WELWYN HATFIELD COUNCIL – DEVELOPMENT CONTROL
DELEGATED REPORT

APPLICATION No:	S6/2011/2583/FP
APPLICATION Site:	7 Gorseway

The proposal is to convert the existing garage in to habitable accommodation with a separate store room behind.

Drg No. 2383-1 Rev

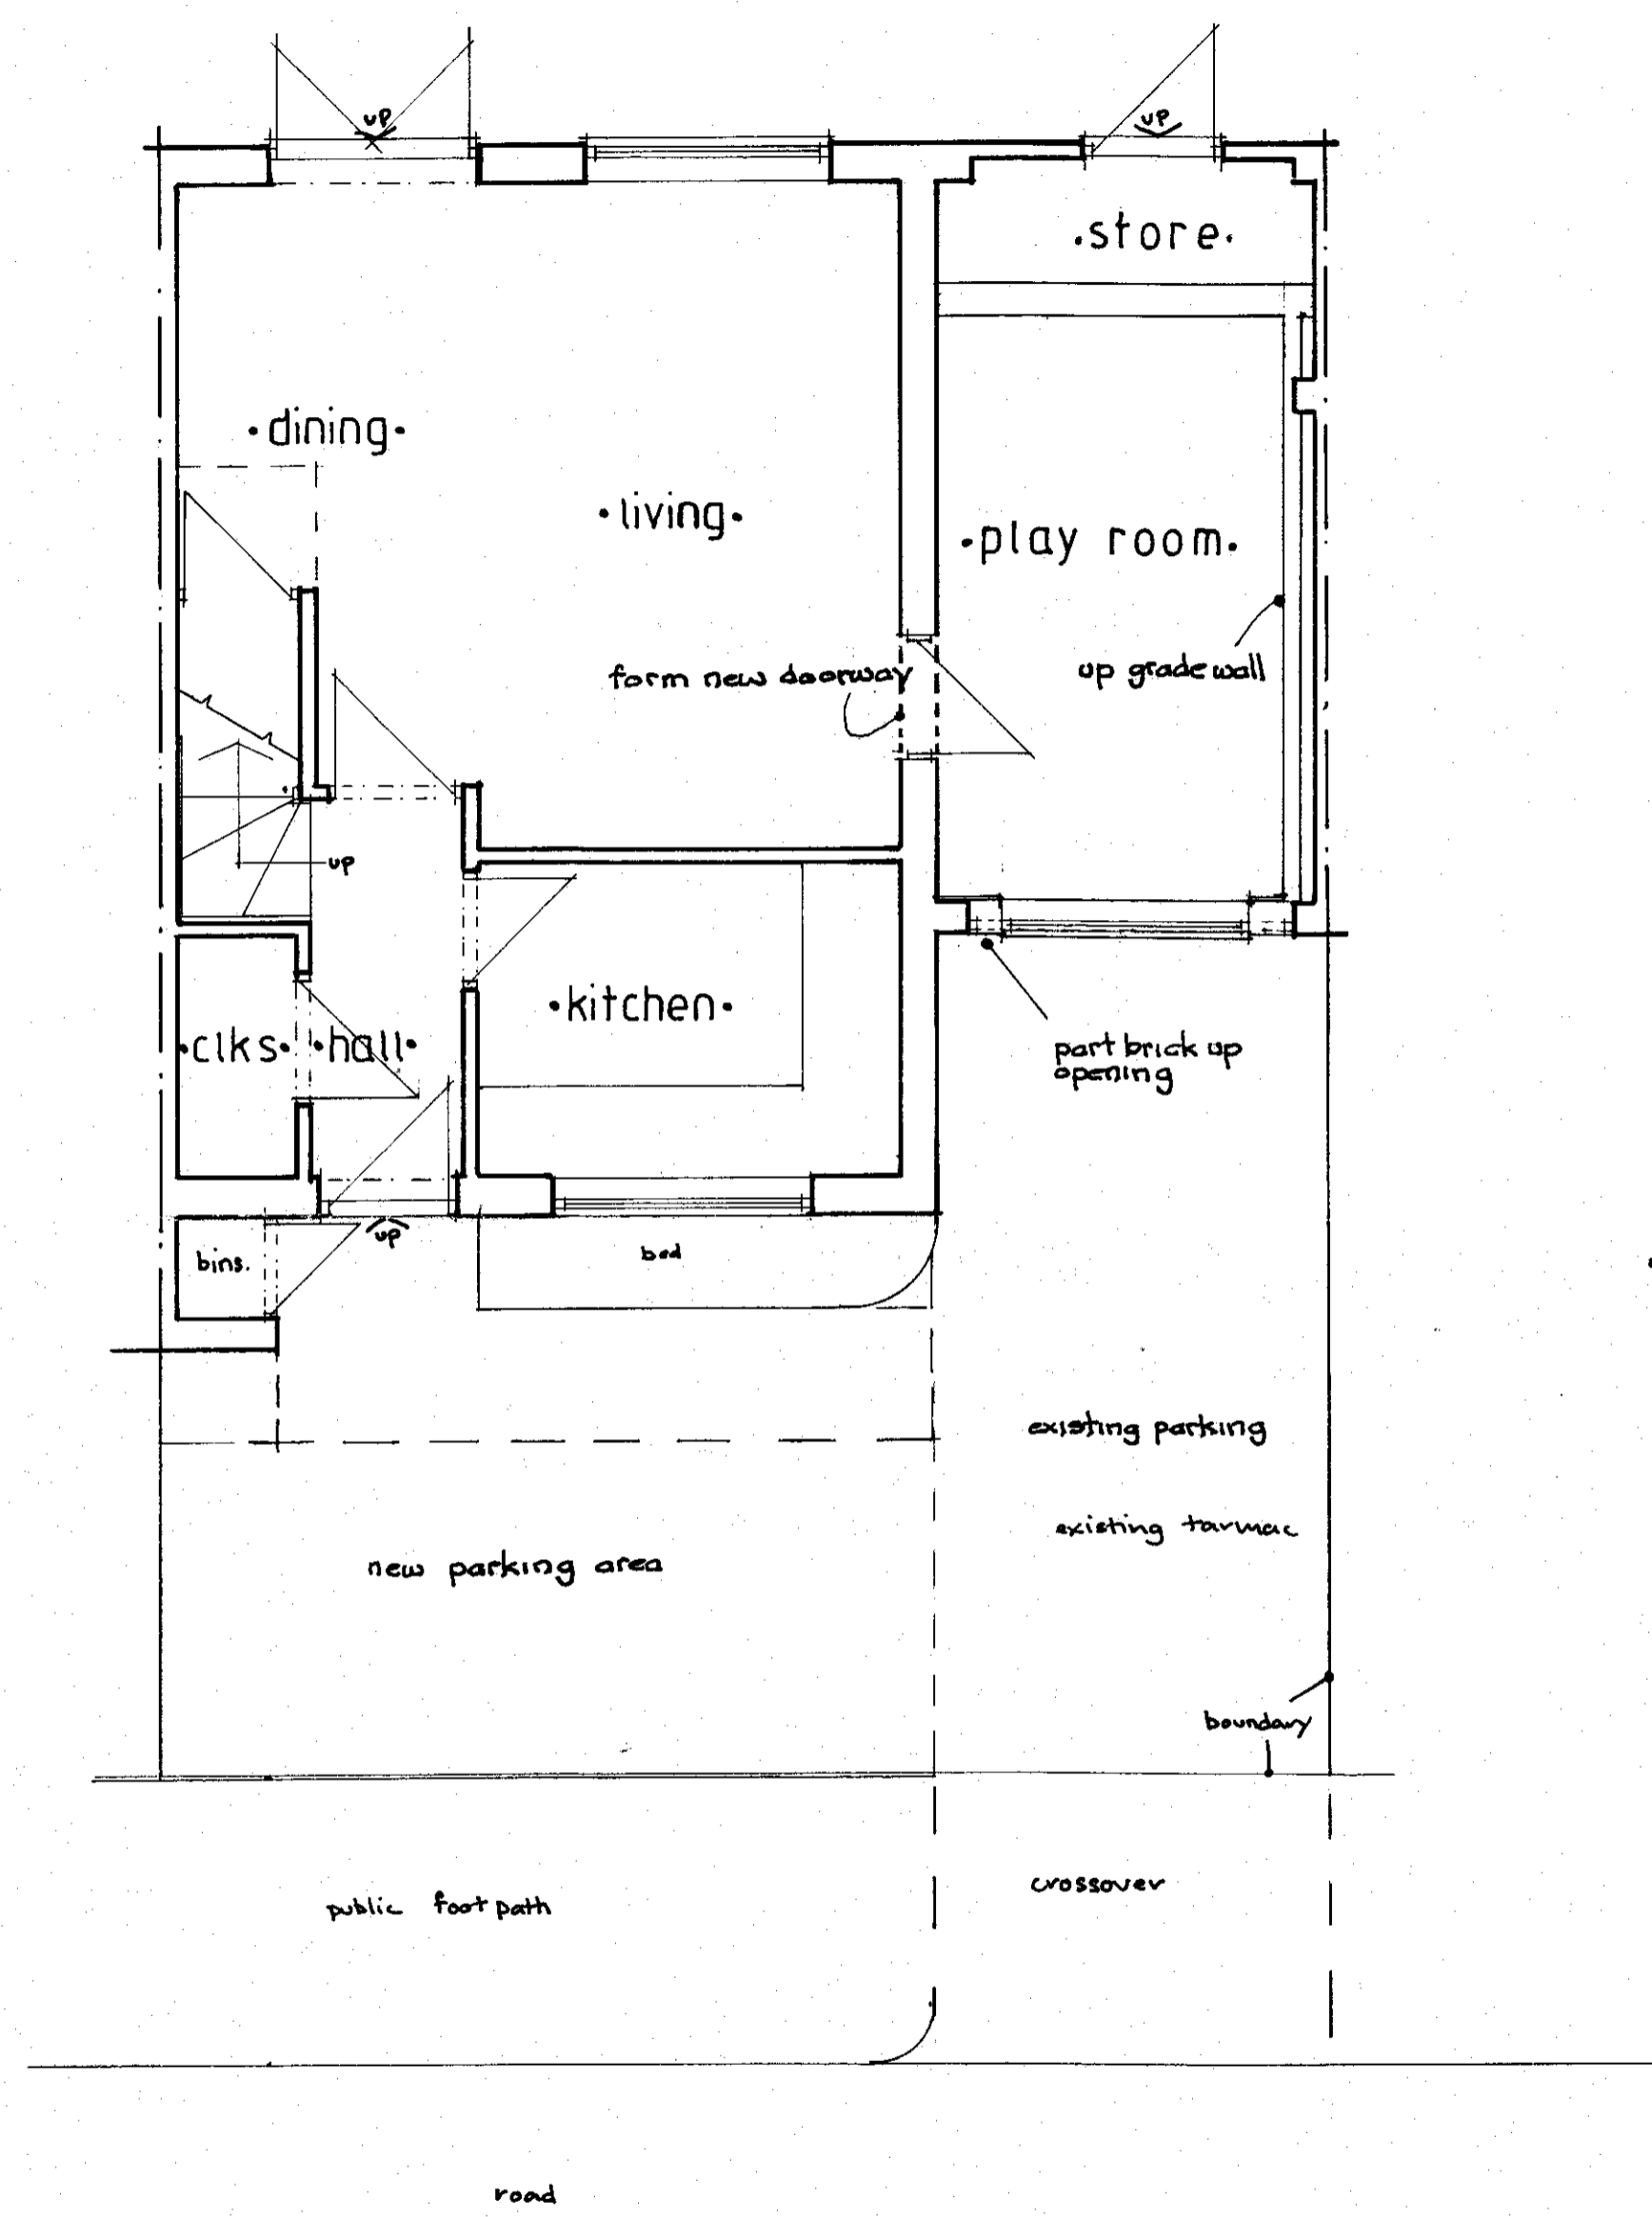
The proposed changes to convert the existing garage into habitable accommodation would require altering the appearance of the dwelling at the front by change the garage door to a window in surrounding brickwork.

These proposed changes which include a window that would reflect the design of the existing kitchen and the use of matching materials, including the brickwork, are considered to be in keeping with the character of the existing dwelling and the surrounding area.

Subject to a planning condition requiring the use of matching materials, this part of the proposal would comply with Local Plan Policies D1 & D2 and the SDG and Policy ENV7 of the East of England Plan.

In regards to the proposed changes requiring the hardsurfacing of the front lawn to tarmac, it is necessary to consider the impact of this change on not only the character of the existing dwelling, but that of the wider existing development of neighbouring residential properties.

The proposal would result in the loss of all the soft landscaping to this dwelling, apart from the planting bed between the path to the front door and under the kitchen window.

As such, this would leave only a very small area of soft landscaping. Whilst the loss of this area of grass would be limited in size to that when compared to that of all the combined areas of soft landscaping for the wider surrounding housing development, it still provides an important feature in softening the appearance of not only the application dwelling but that of the wider streetscene.

Furthermore, its proposed use as a parking space would mean that at times there would be a parked vehicle in this location, adding further to the loss of the visual amenity of the streetscene.

The proposal provides a replacement parking space in front of the dwelling which would overcome the loss of the garage space.

4. The proposed hardsurfacing shown on approved drawing 2383.1 for the replacement parking shall be implemented prior to first occupation of the development hereby approved and retained thereafter. This hardsurfacing shall be made of porous materials, or provision shall be made to direct run-off water from the hard surface to a permeable or porous area or surface within the curtilage of the dwellinghouse.
